## Warwickshire County Council Comments on Applicants Response to Written Representations

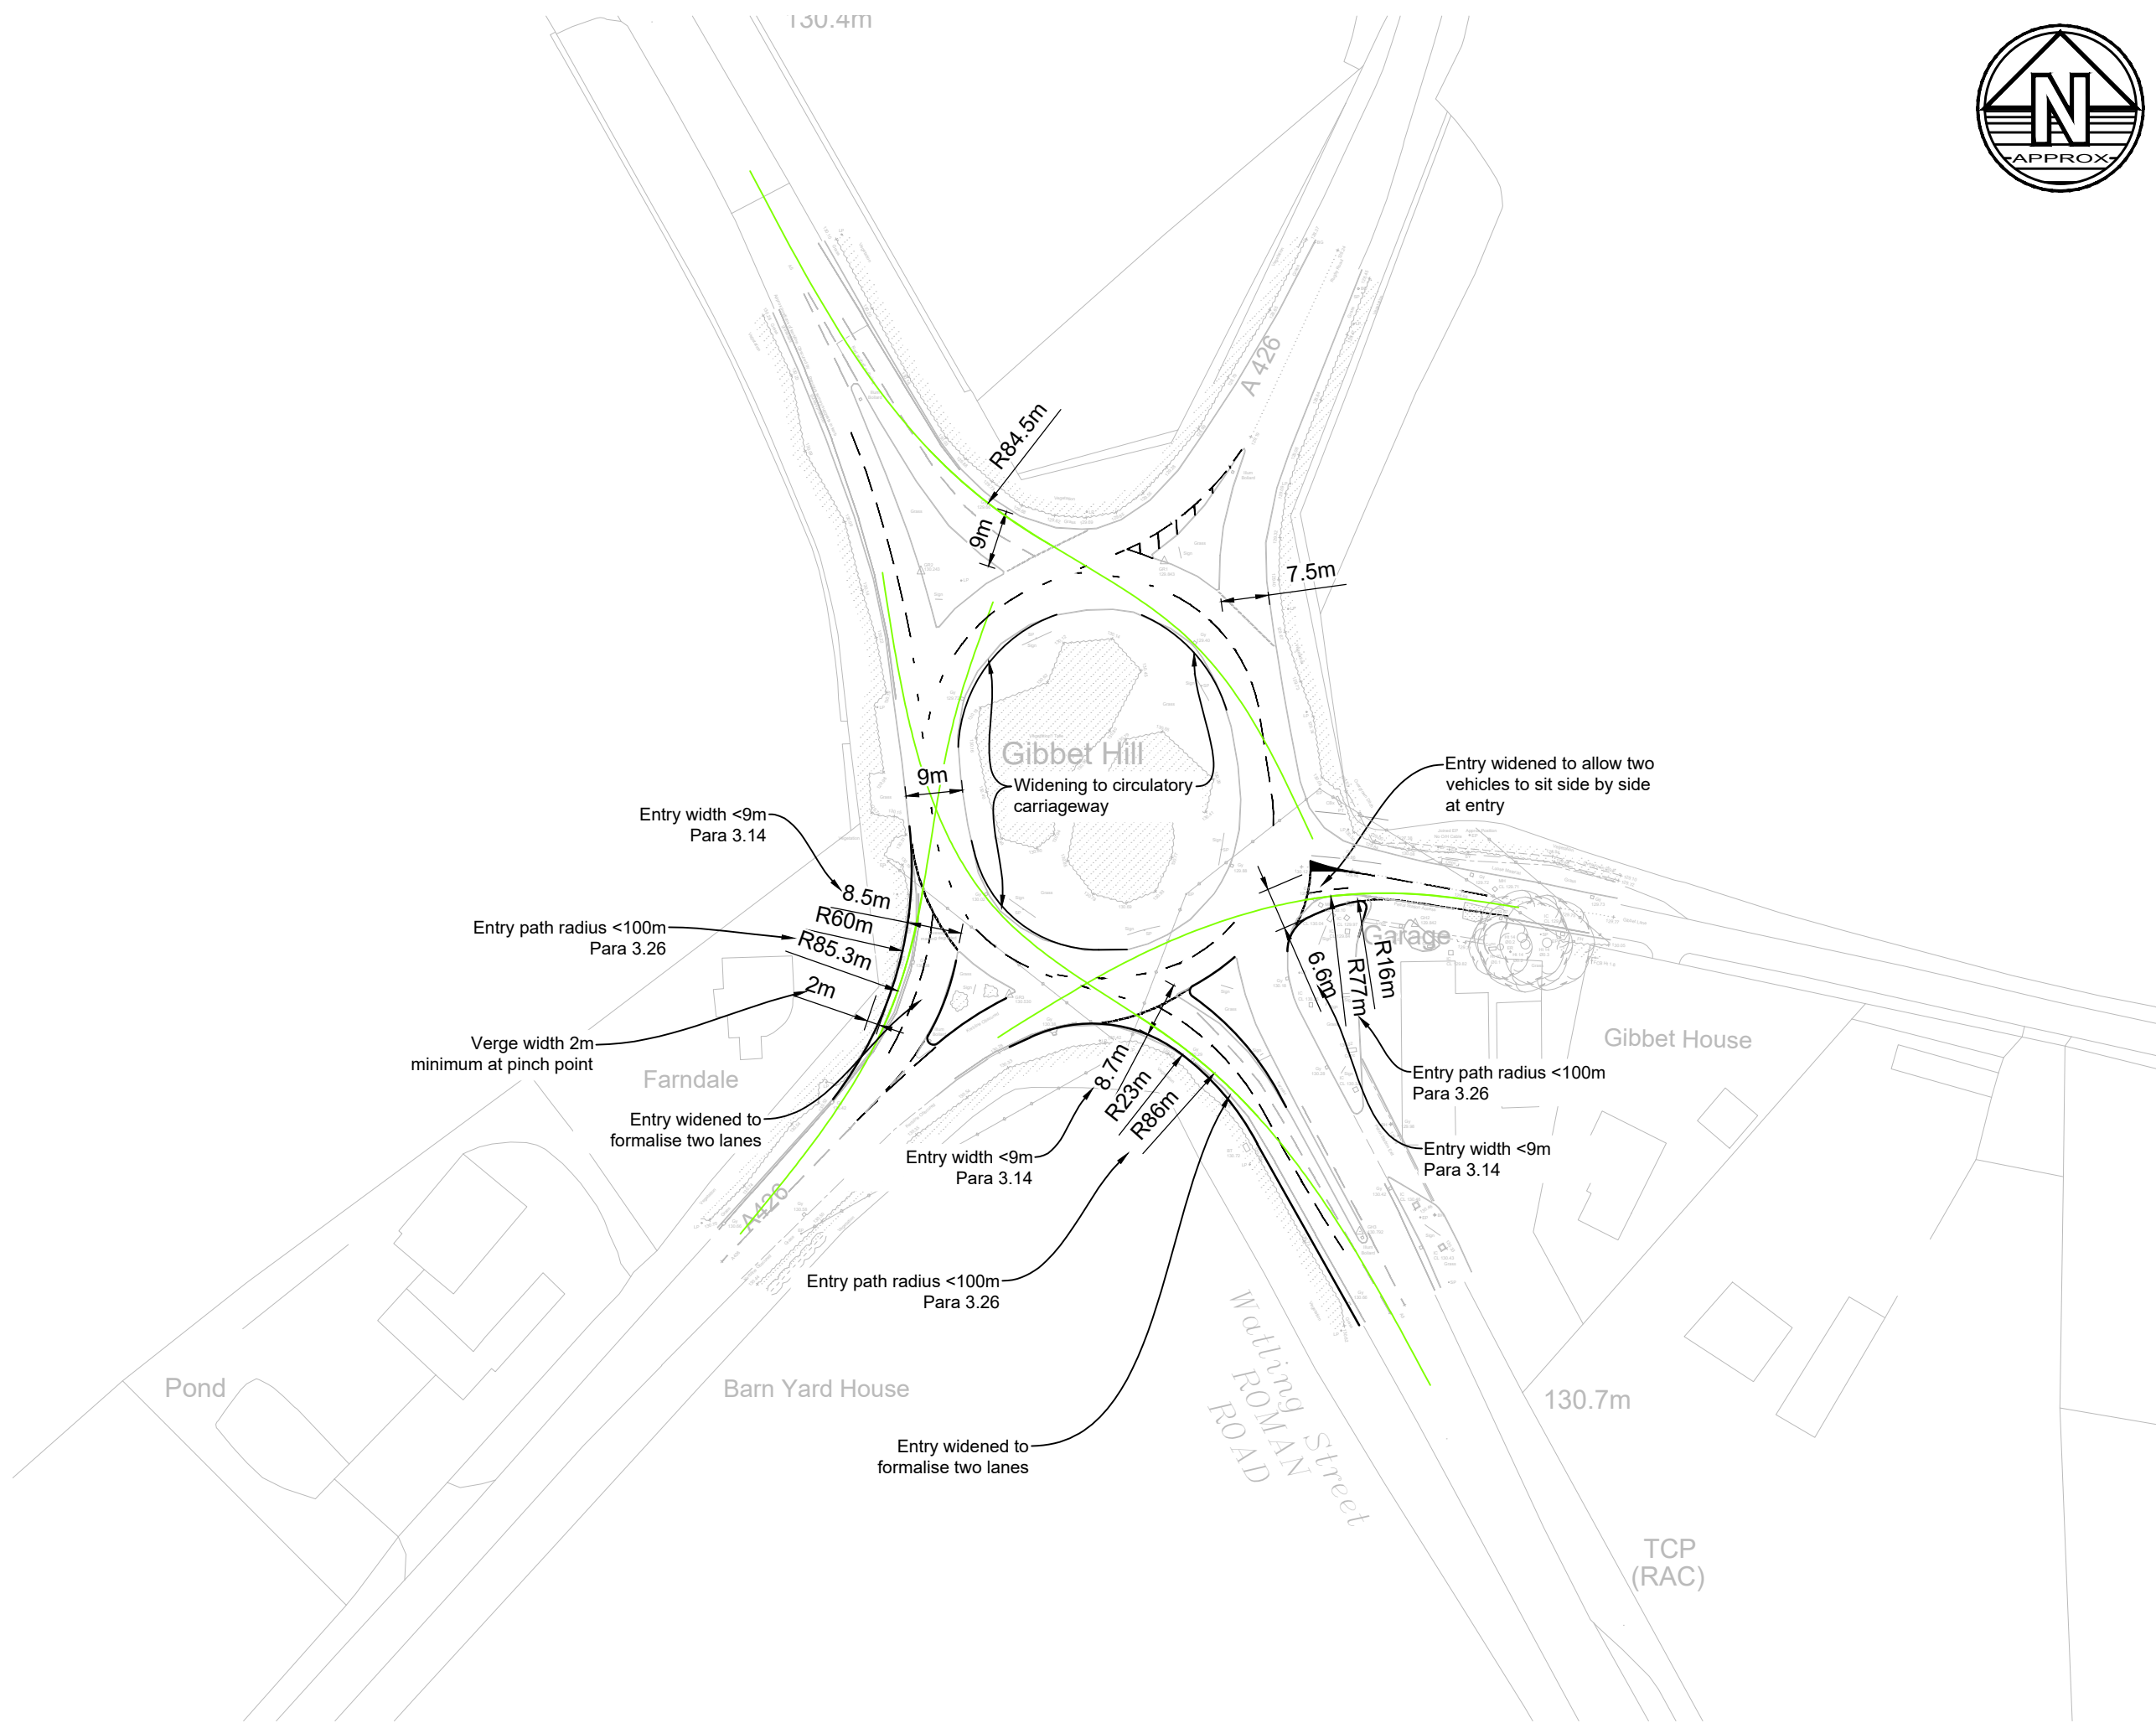
<p>Warwickshire County Council</p>	<p><b>A5/A426 Gibbet Hill (NB. the A426 is part of the Major Road Network)</b></p> <p>This junction was to be signalised to mitigate the impacts of DIRFT III in accordance with their planning consent, but they have not yet triggered for this improvement. However it is understood that the promoter of that development site is in discussions with National Highways.</p> <p>This junction was also to be signalised to mitigate the impacts of Symmetry/Magna Park as required as part of that planning consent. However, as part of their discussions with National Highways with regard to the detail around the scheme design, the promoter of Magna Park South used the VISSIM model to assess development impact given the junction interactions with M6 junction 1 and the A426 corridor on the Major Road Network (MRN) in North Rugby, and we would expect the Hinckley National Rail Freight Interchange promoter to use the same approach to assess the impact of development traffic.</p> <p>National Highways considered the junction signalisations proposals and recognised that due to these committed developments and other Local Plan led growth in the area, the proposed signalisation scheme will not accommodate the cumulative impact of various consented developments. As a</p>	<p>To be discussed with TWG members ahead of Deadline 3</p> <p><a href="#">See above.</a></p>

National Highways does not have a committed scheme at this junction as highlighted previously and therefore the baseline position for the modelling must be the existing non-signalised junction arrangement (i.e., a Do Nothing)

Blocking back towards M6 Junction 1 along the A426 and platooning of traffic between M6 Junction 1 and the Gibbet Hill junction can only be considered within the VISSIM model.

<p>in the context of the effects arising from delivery of any proposed mitigation at Gibbet Hill.</p> <p>Therefore for these reasons Warwickshire County Council does not accept the modelling or proposed mitigation at this location, and requires the VISSIM modelling to be carried out.</p>	
<p>Warwickshire County Council</p>	<p><b>A5/A47 The Longshoot/A47 Dodwells</b></p> <p>The Transportation Assessment identifies a 3% impact at the A5/The Longshoot junction within the PRTM modelling, and conclude that this is not considered a sufficient impact to warrant further assessment.</p> <p>This is a critical junction on the Strategic Road Network, and its efficient operation is critical to the local road network. Any additional queues and delays will impact on the network, and in order to consider the safety and efficiency of the network that modelling has been requested.</p> <p>All developments that are shown to be assigning traffic through the A5/Longshoot/Dodwells junctions, including Padge Hall Farm, and several other large sustainable urban extensions (within Warwickshire and Leicestershire) have been required to use the National Highways VISSIM model and we would</p>	<p>To be discussed with TWG members ahead of Deadline 3</p> <p><a href="#">See above.</a></p>
